# Rezoning Transportation Analysis

Petition Number: #2022-051

Date	Description
08-24-2022	First Review (KP)

CONCEPT PLAN - SF ATTACHED

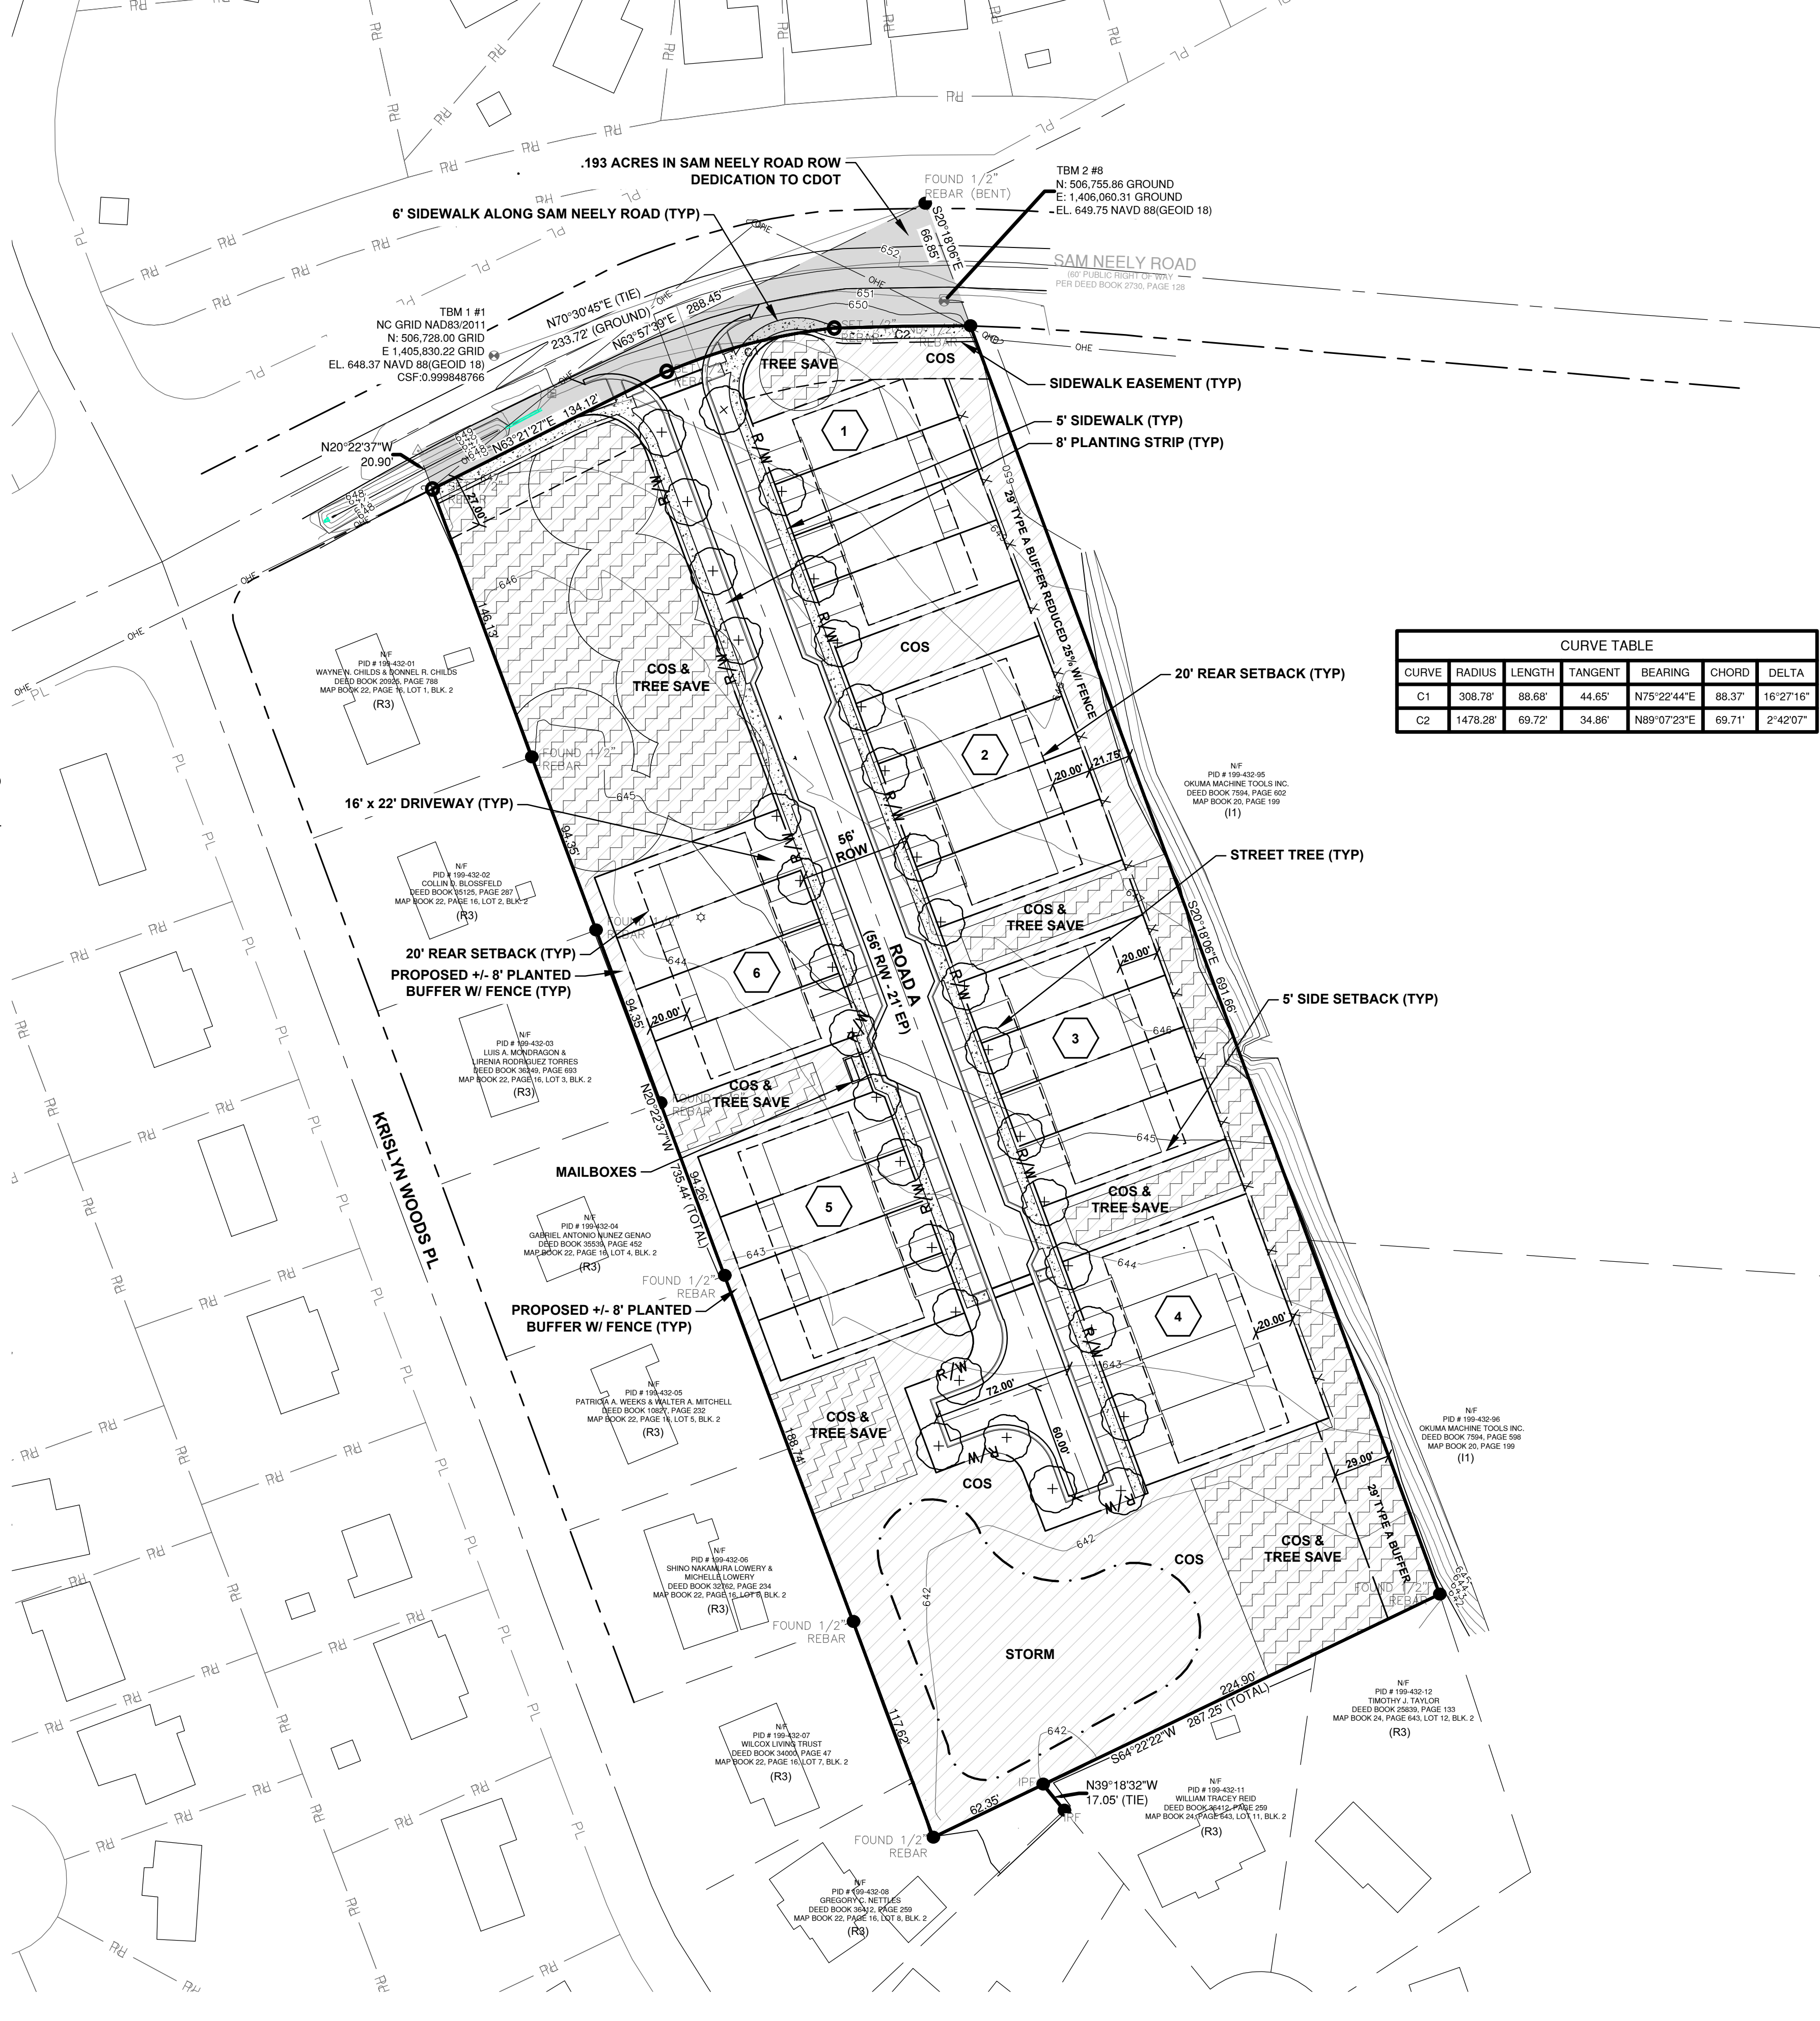
1. Revise the site plan and conditional notes by committing to construct curb and gutter, along the site's frontage of Sam Neely Road, measured 19-feet from the existing centerline to back of curb.

Label and dimension the back of curb from the existing centerline of Sam Neely Road.

3. Revise site plan and conditional note(s) to commit to dedicate 43-feet of right-of-way along the site's frontage of Sam Neely Road.

The site plan shall label and dimension the right-of-way from the road centerline.

4. Revise site plan and conditional note(s) to commit to construct an 8-foot planting strip, and 12-foot shared-use path along the site's frontage of Sam Neely Road. The site plan shall label and dimension both items from the back of curb and gutter.

5. Revise the site plan and conditional notes to commit to construct proposed Public Road A in accordance with CLDSM U-02, local residential medium street.

6. Revise the site plan by removing the proposed crosswalk markings, across Public Street A, and extending the sidewalk around the hammerhead.
